RE: Application MP09_0016

We write as the owners of a unit in 40 Stephen Street about the proposed development of the Scottish Hospital opposite our property.

Submission for Job: #3779 MP10_0016 - Project Application for Seniors Housing and Care Facility
https://majorprojects.onhiive.com/index.pl?action=view_job&id=3779

Site: #2200 Scottish Hospital, 2 Cooper St, Paddington
https://majorprojects.onhiive.com/index.pl?action=view_site&id=2200

Tree protection zones

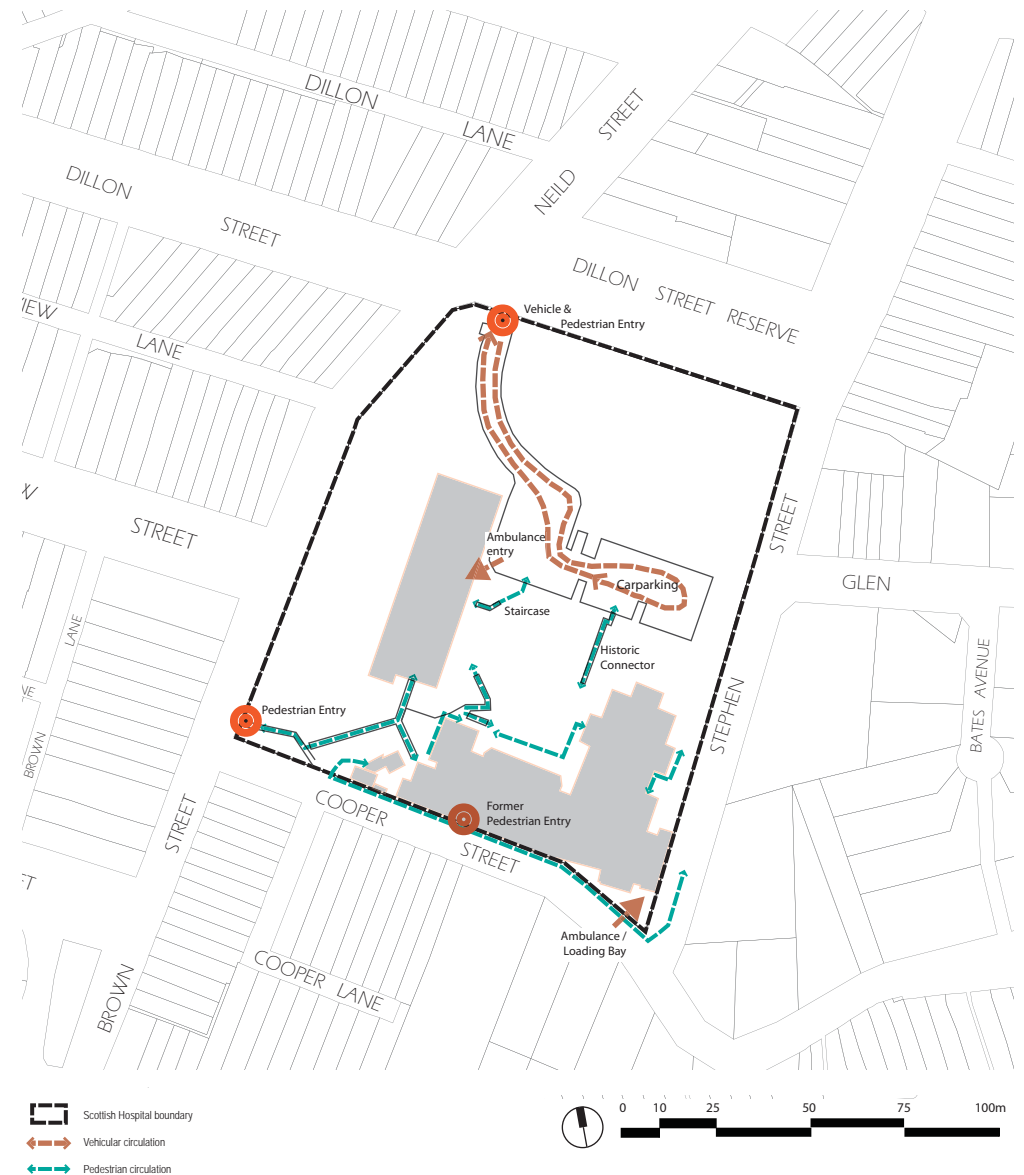
We are very concerned that the plan slates all trees along Stephen Street to be removed. These are a wonderful asset to the community softening the environment, providing shade and attracting native fauna. Surely their removal is against the retention order by Woollahra Council Tree Preservation Order? In this day and age the removal of healthy mature trees is abhorrent.

STEPHEN STREET ELEVATION

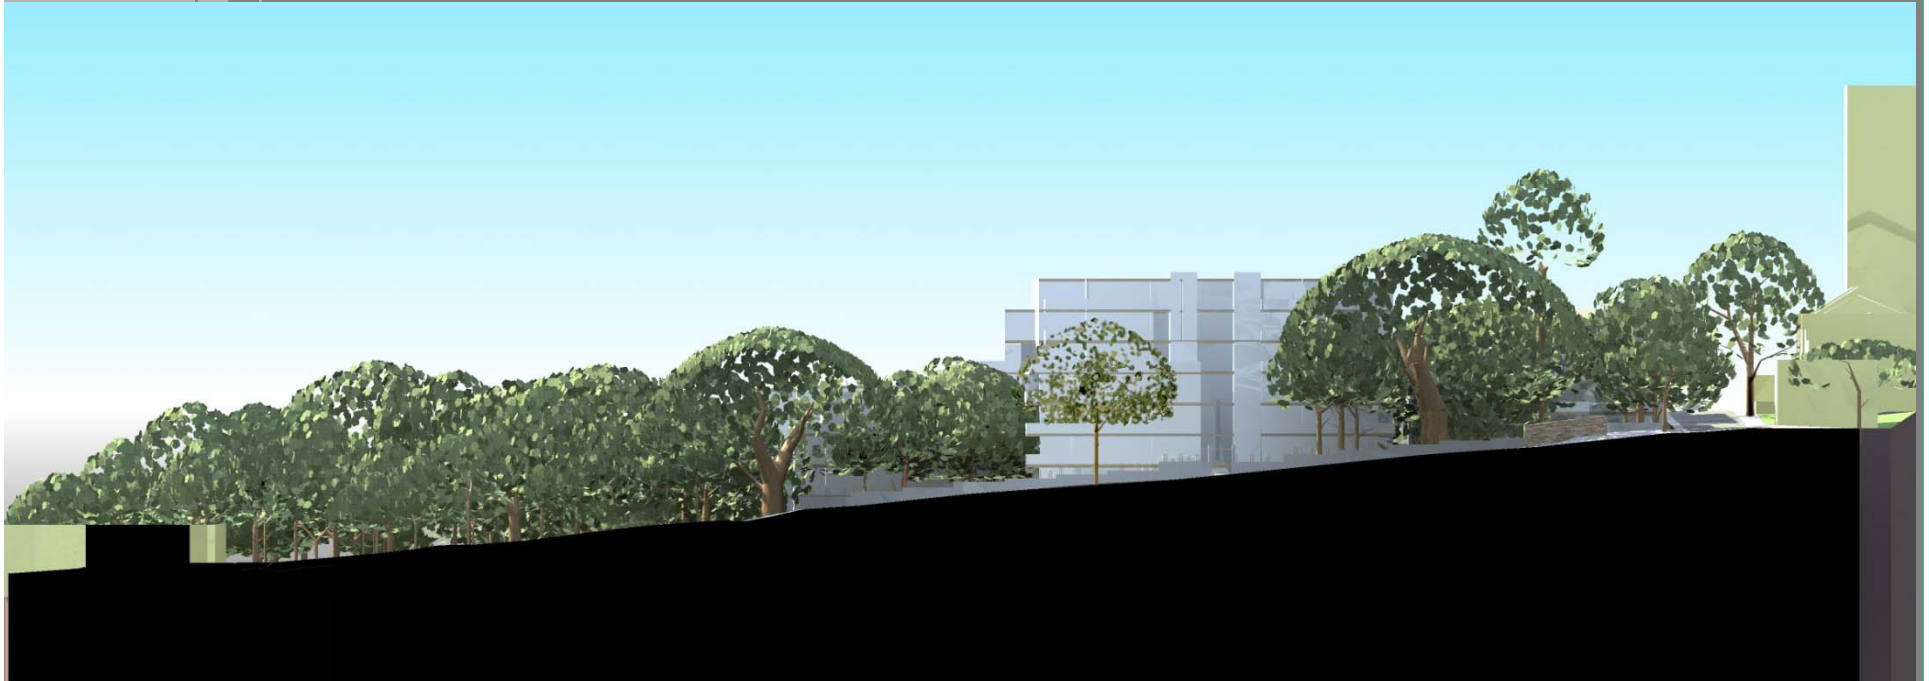
We would like greater setbacks between the aged care facility and 40 Stephen Street. The proposed plan does not meet SEPP 65 recommendation of 18 metres.

The proposed service vehicle entry for the hospital is opposite the foyer of 40 Stephen Street. There is no current service entry there at present and the narrowness of Stephen Street makes it completely unsuitable for use by service vehicles for a hospital. Also there is no turning area at the end of Stephen Street. The present service area is in Brown Street. Why can't this remain the service area entry for the whole hospital?

We also are concerned that the air conditioning units are located opposite 40 Stephen Street. We want them relocated so that they do not impact on the residents of our block.

Also we do not want commercial laundry use or kitchen ventilation in Stephen Street or garbage pick up. Residents were told in the consultation sessions that there would be no garbage pick up from Stephen Street. Not only is the street narrow and unsuitable but the noise generated by vehicles turning and backing in and out of loading bays will have a significant effect on the quality of life of our residents.
